# Charlotte Department of Transportation

## Memorandum

**Subject:** Rezoning Petition 08-139: Located on the north side of Ballantyne Commons Parkway between Rea Road and Williams Pond Lane (*revised 9/15/08*)

SITE PLAN

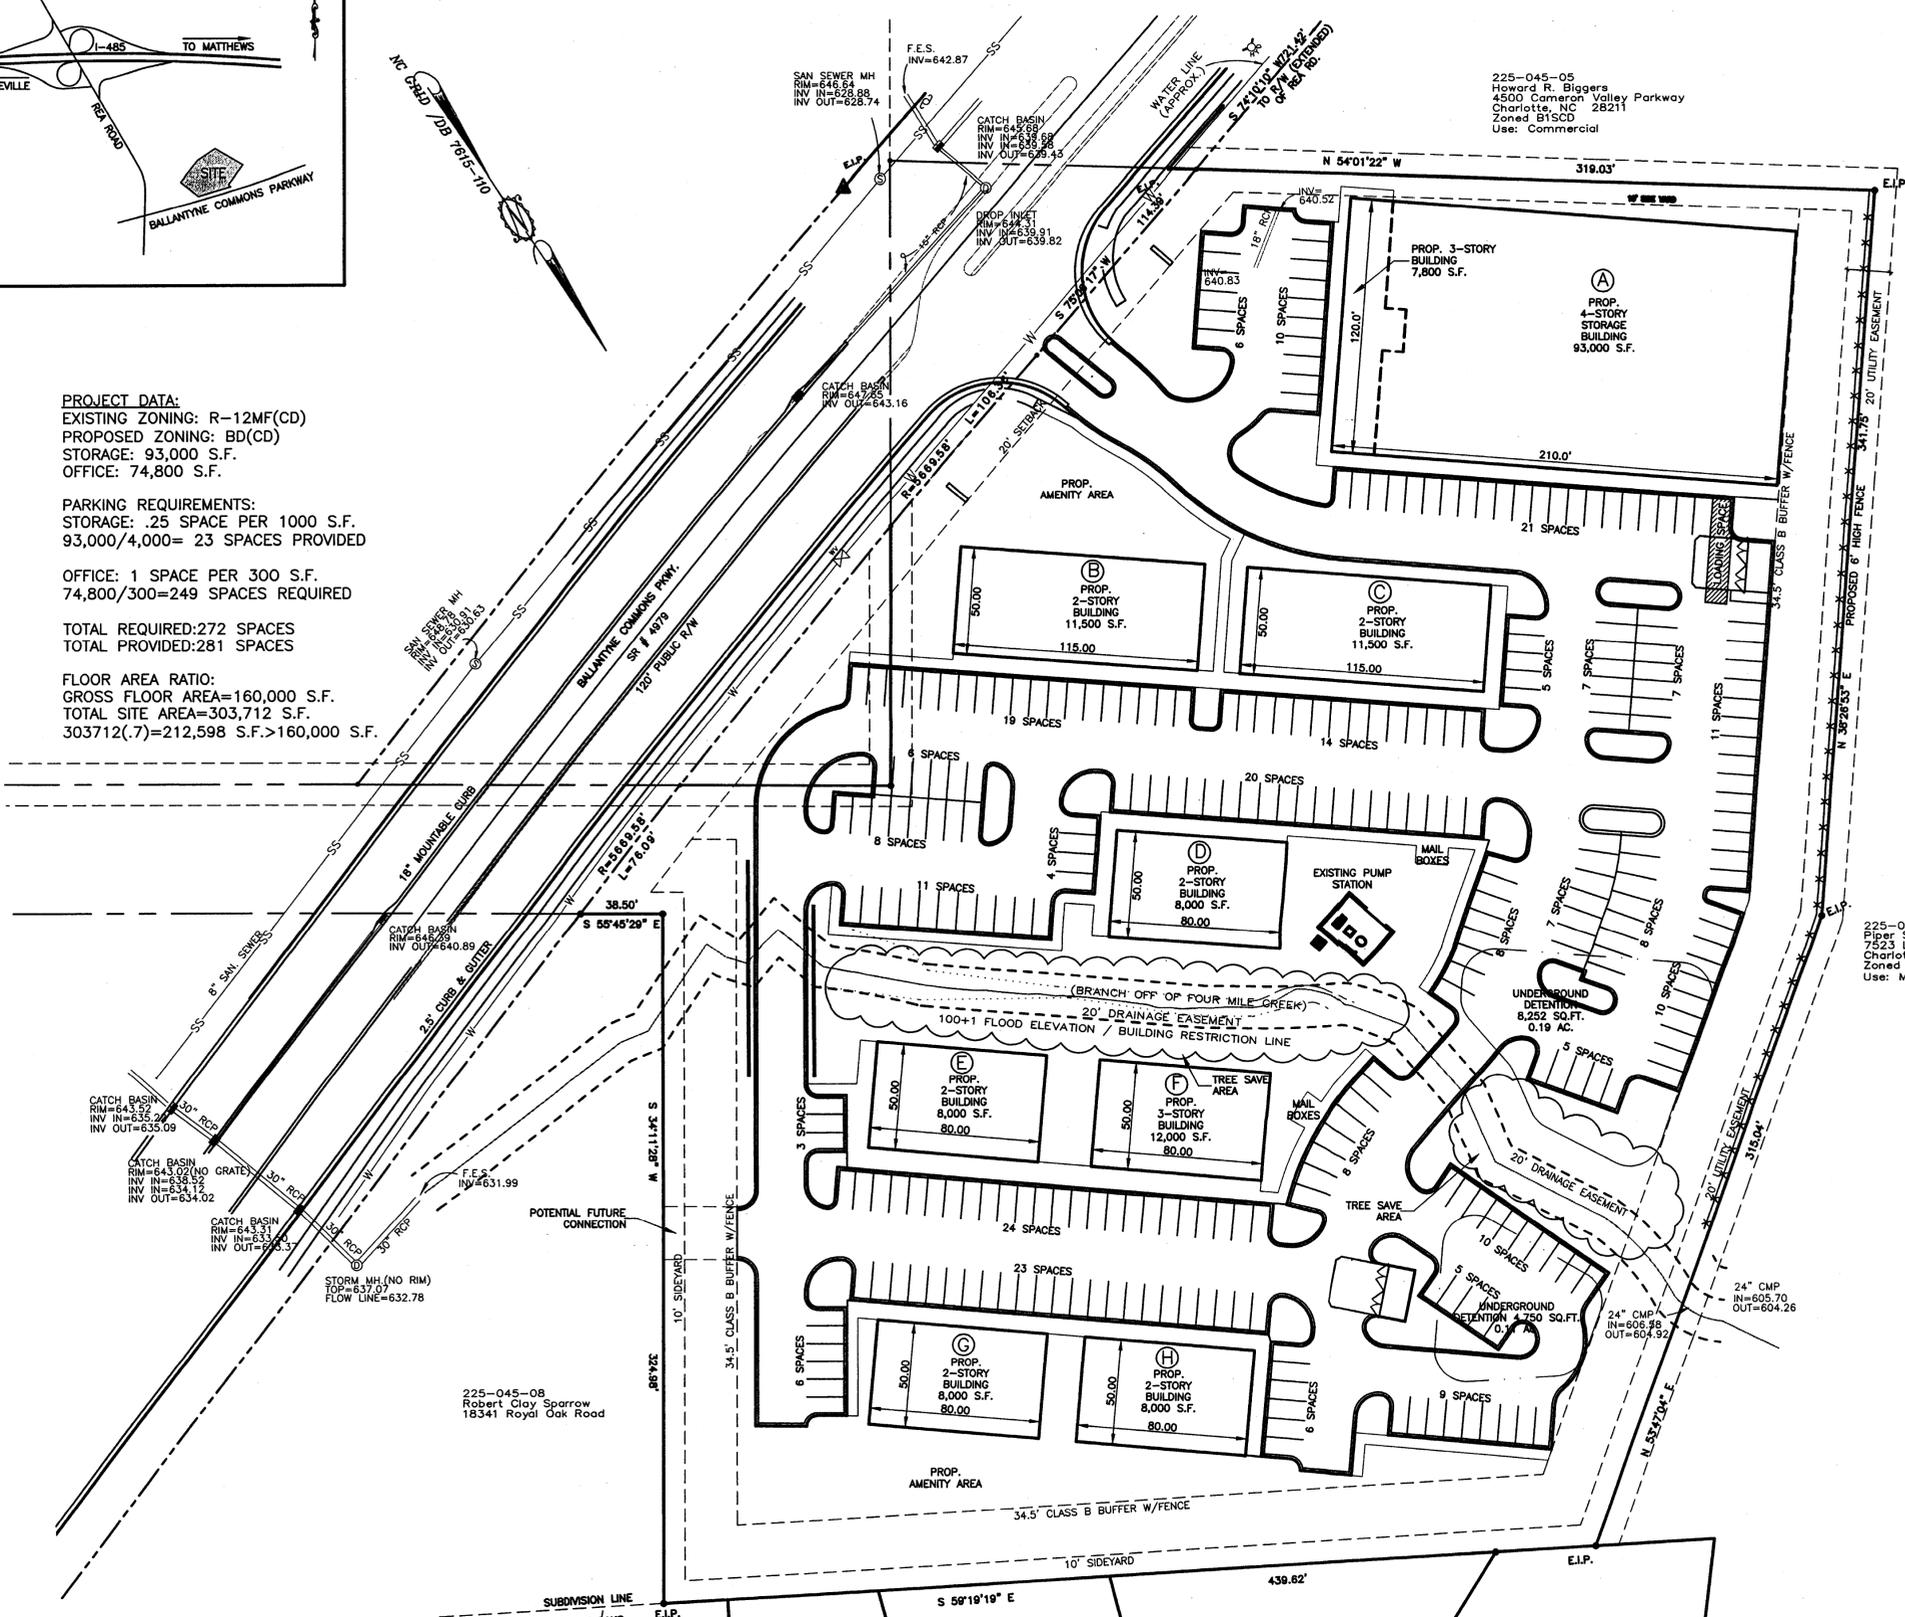
1. This property needs to have cross access/easement with the adjacent property to the east to provide inter-connectivity and access between uses that will not require unnecessary use of Ballantyne Commons Parkway. To facilitate future cross access, the stub driveway shown on the site plan to Parcel 225-045-08 needs to be shown all the way to the property line.  
(*Previous review comment*)

2. Drive aisles through parking lots should be designed to avoid minor offsets. North of Buildings F and H, the configuration of the drive aisles need to be consolidated and better aligned for through movements. (*Previous review comment*)
